Rezoning Transportation Analysis

Petition Number: 2022-214

Date	Description
05.24.2023	First Review (PDM)

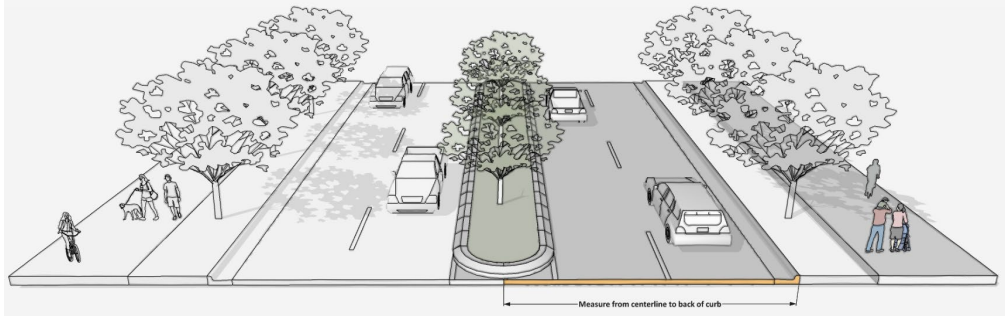
8. Per coordination with NCDOT provide turn lane and access management modifications per the markup below to meet NCDOT Policy on Street and Driveway Access requirements.

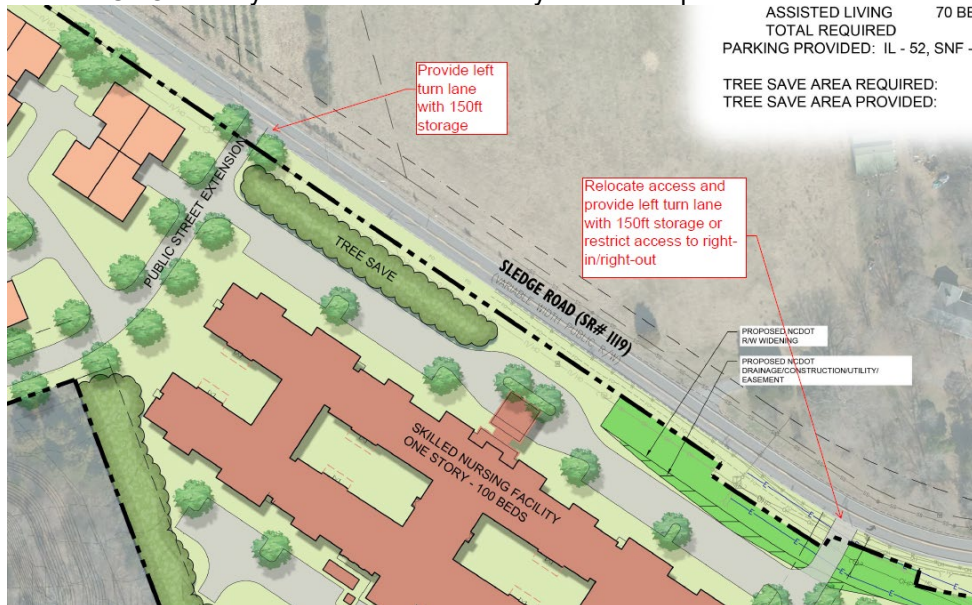
5. Revise site plan and conditional note(s) to provide CLDSM typical section for the proposed public local streets. Sidewalks are required along all public streets.
